From: Damian Sullivan
Sent: 11 September 2014 11:59
To: Andrew Fuller
Subject: RE: CM/30/14/HH - Poole Place, Climping

From: Estella [REDACTED]
Sent: 10 September 2014 12:37
To: Damian Sullivan
Cc: AFA
Subject: CM/30/14/HH - Poole Place, Climping

We would like to substitute a couple of drawings under the above application reference. Please find attached drawings 102A & 105A

14637/ 102

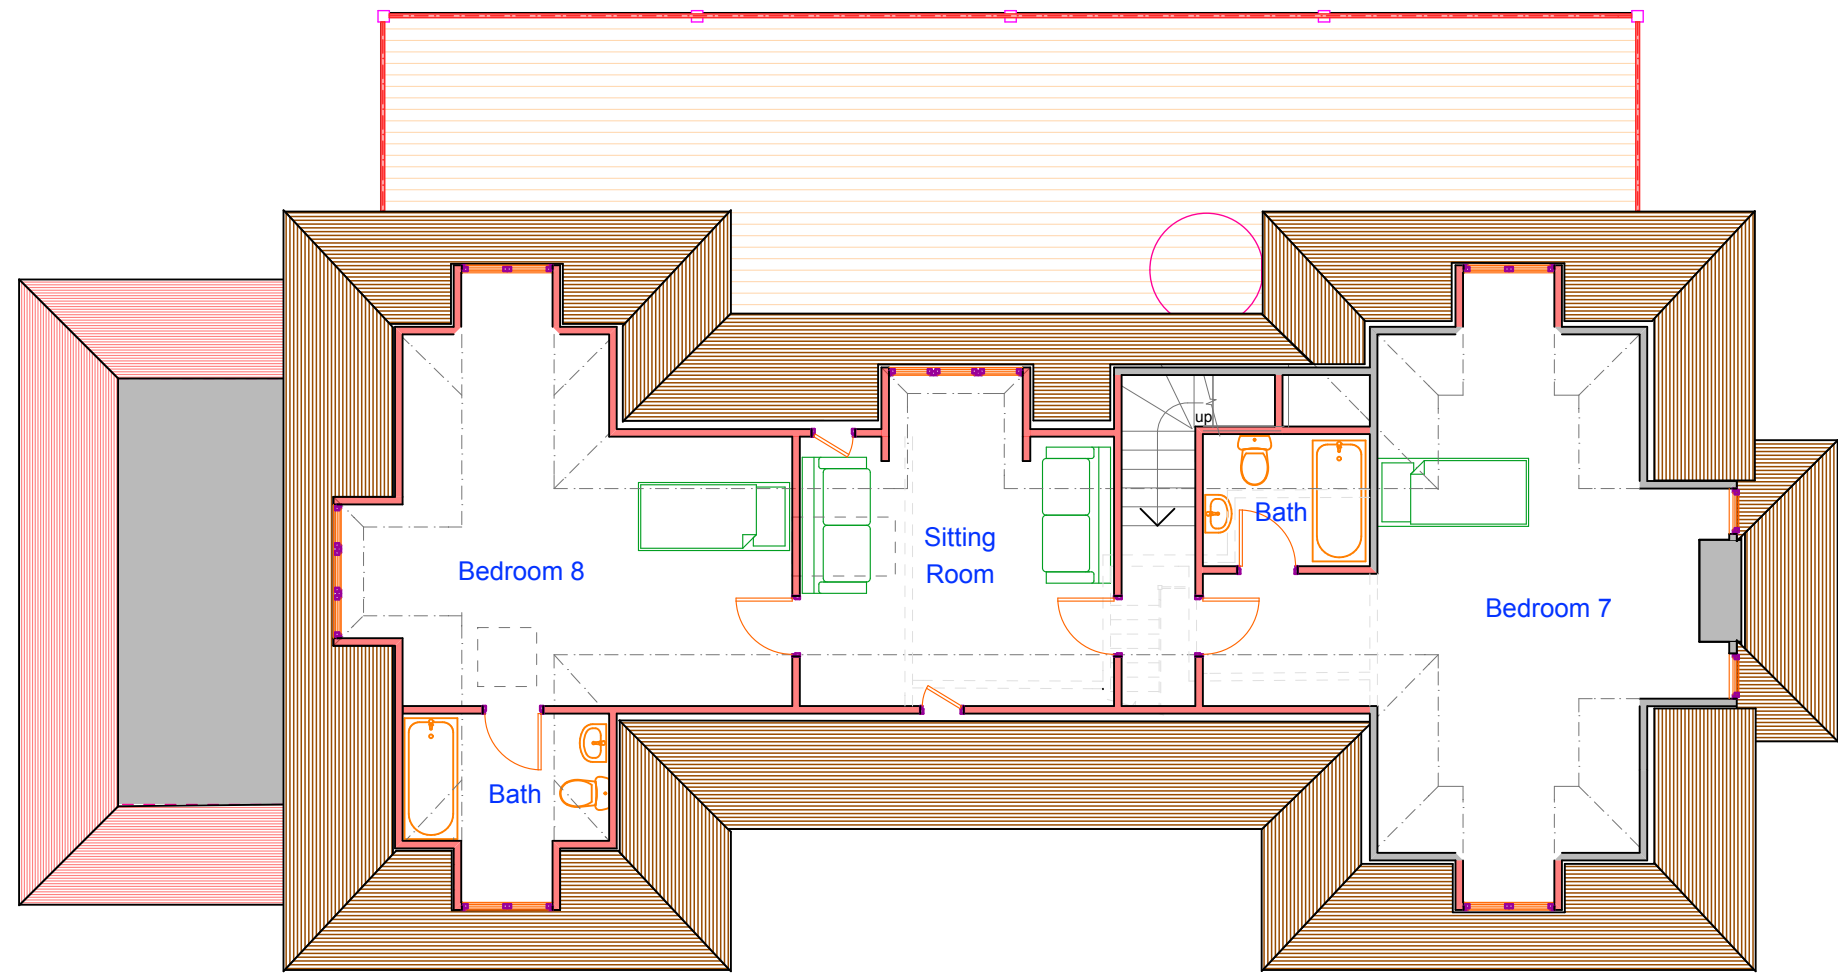
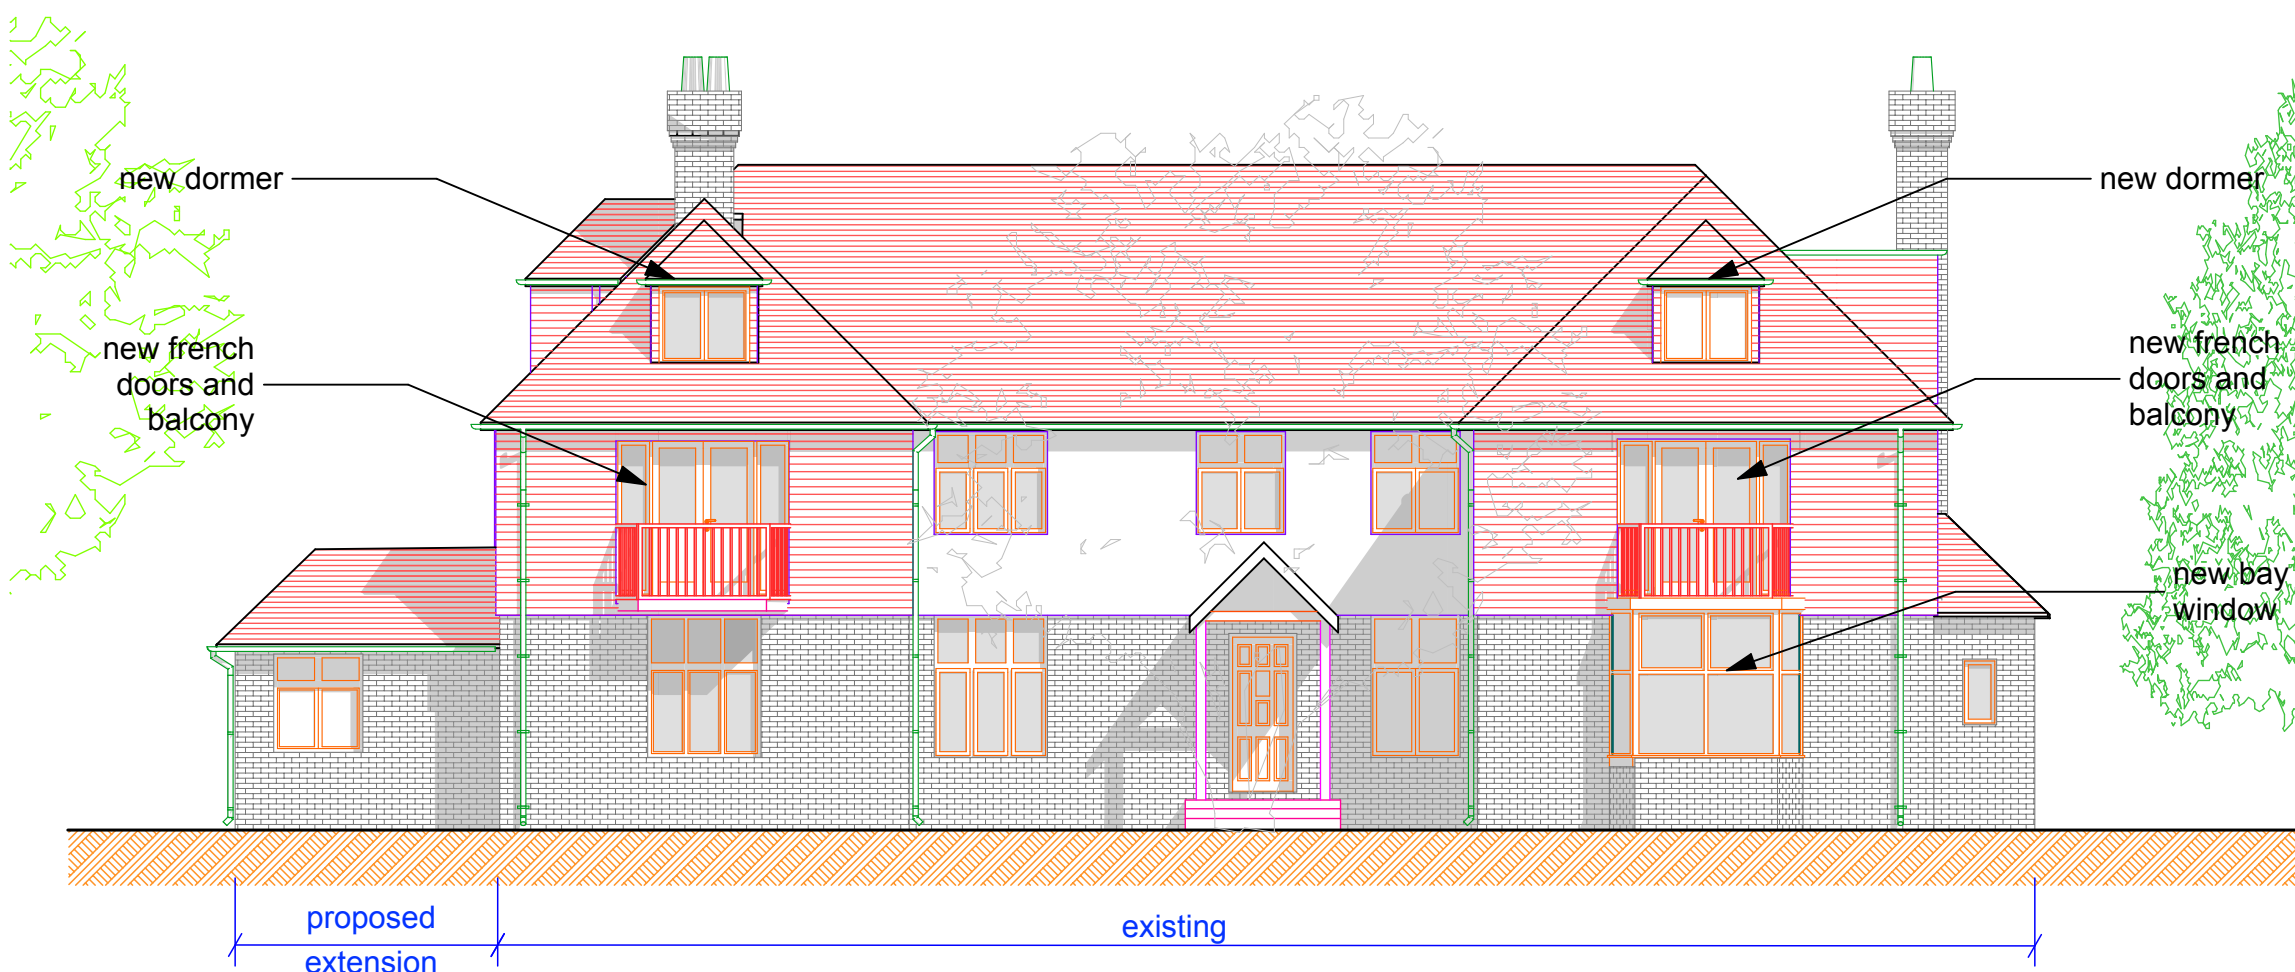
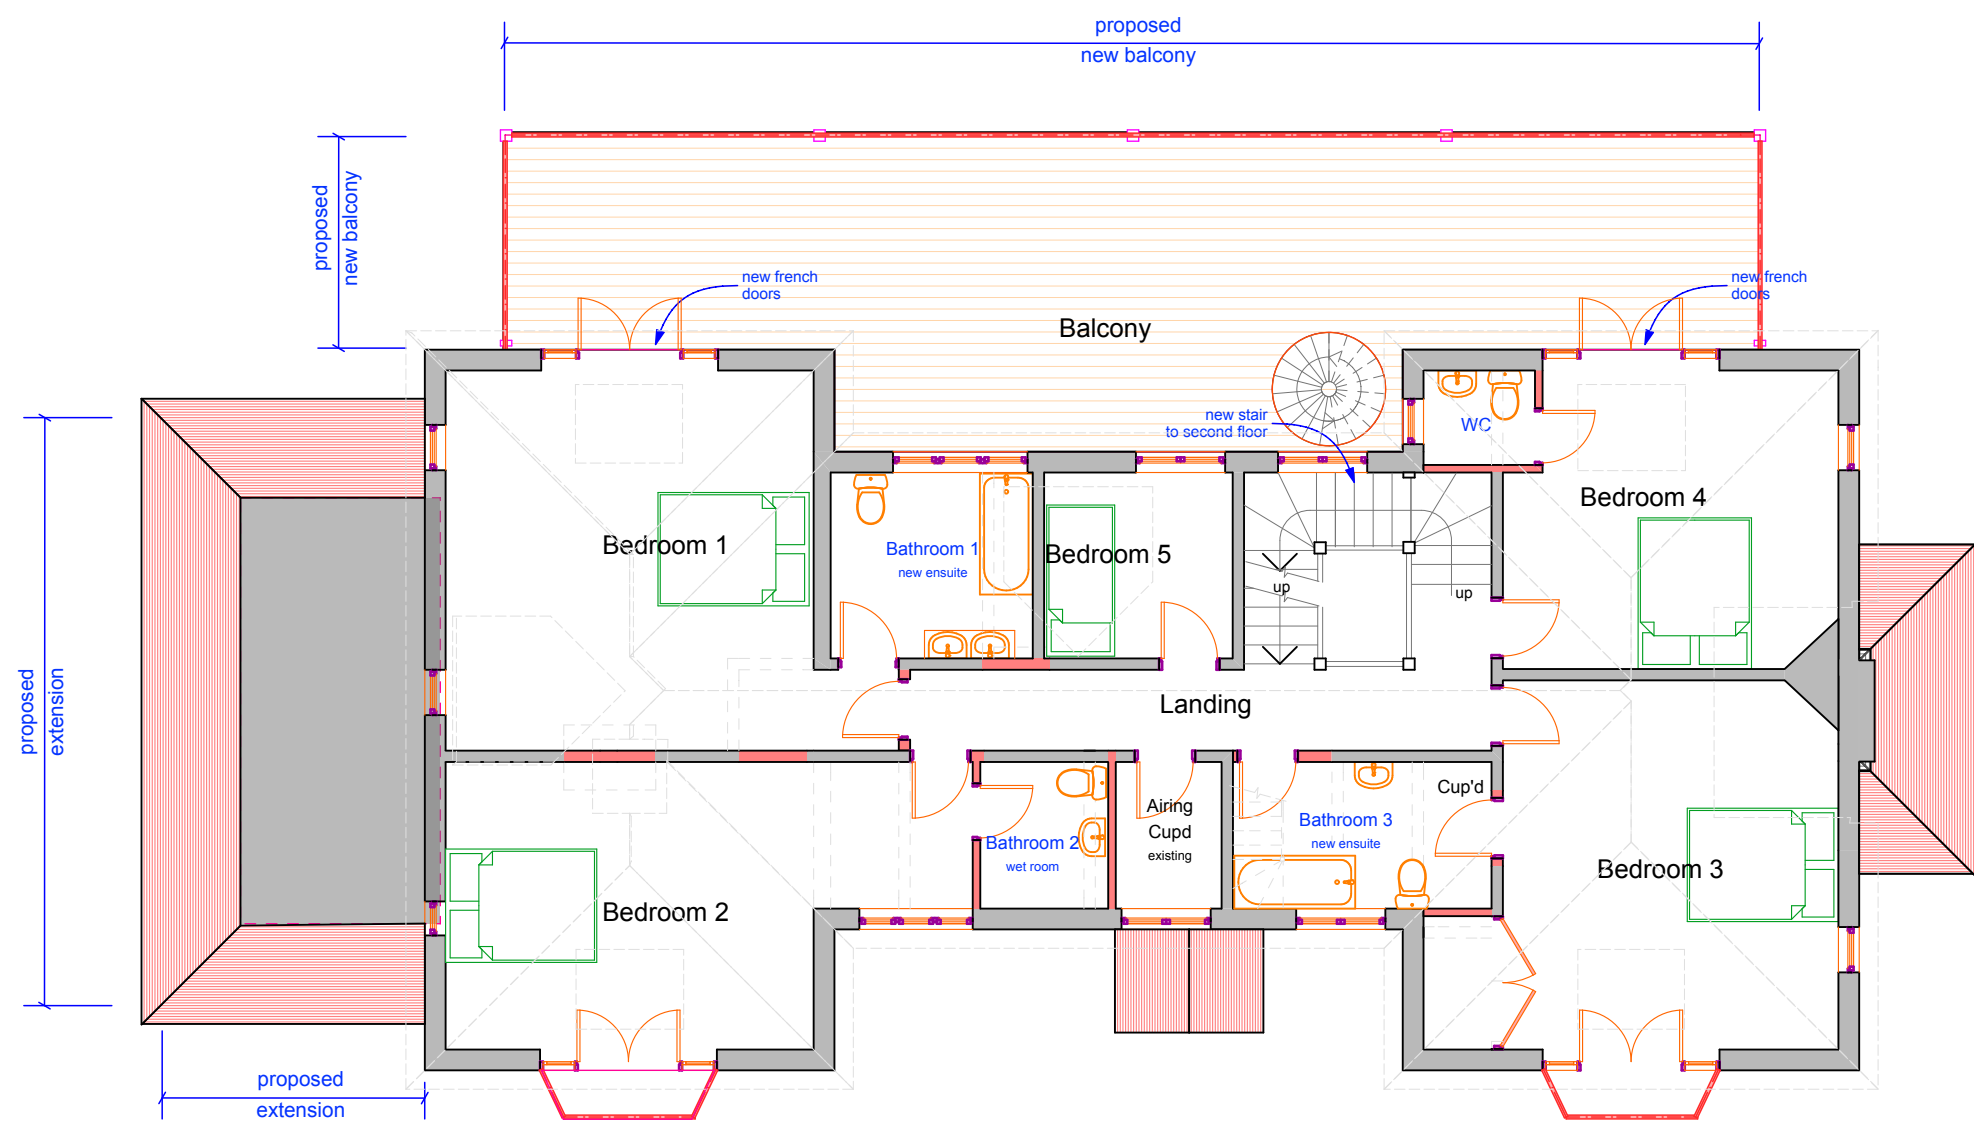
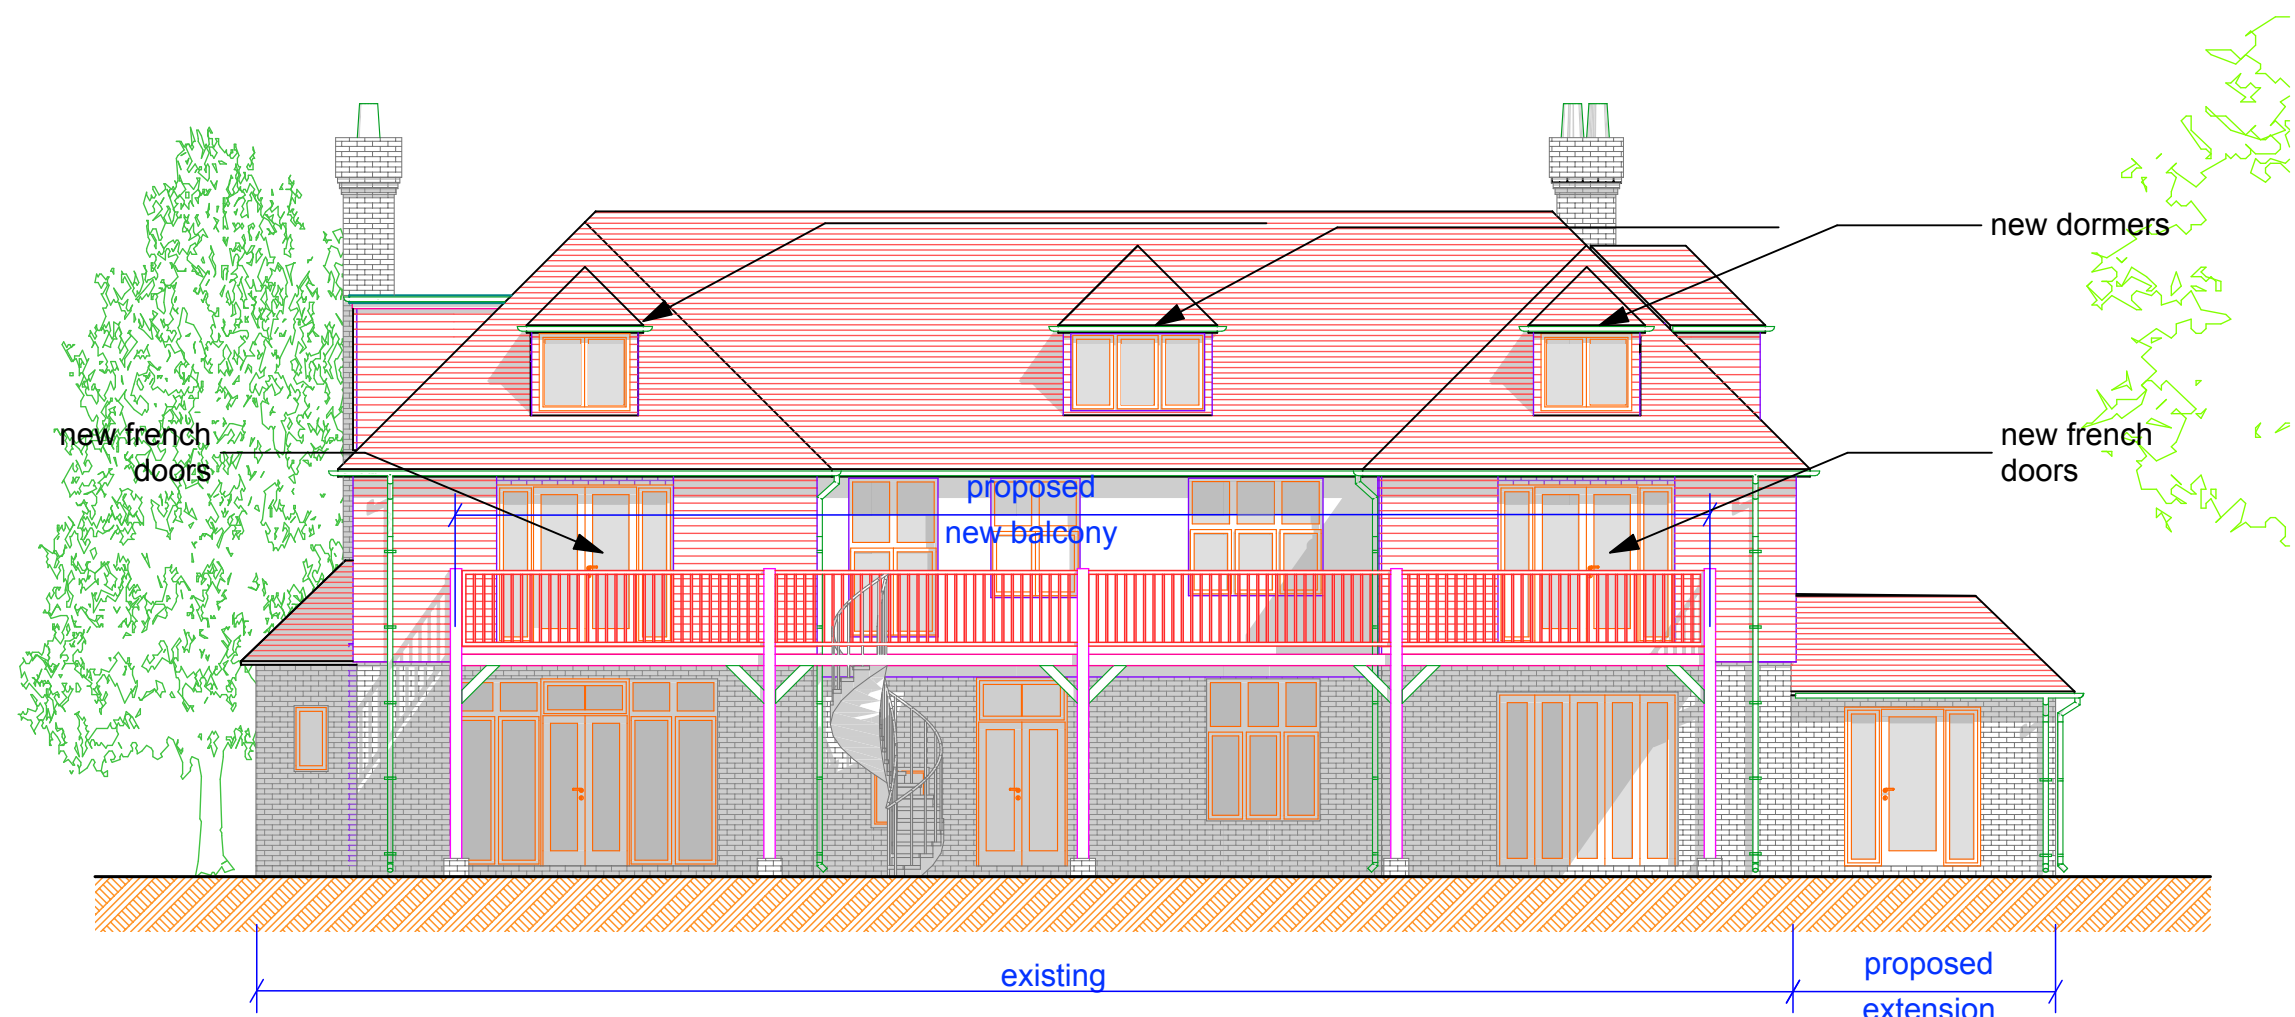
Unfortunately due to the changes being made especially the swimming pool, although even the dormers on the east elevation, mean that these cannot be accepted as substitute drawings as they will require re-advertising. You are of course welcome to withdraw the application and start again with a resubmission at this point.
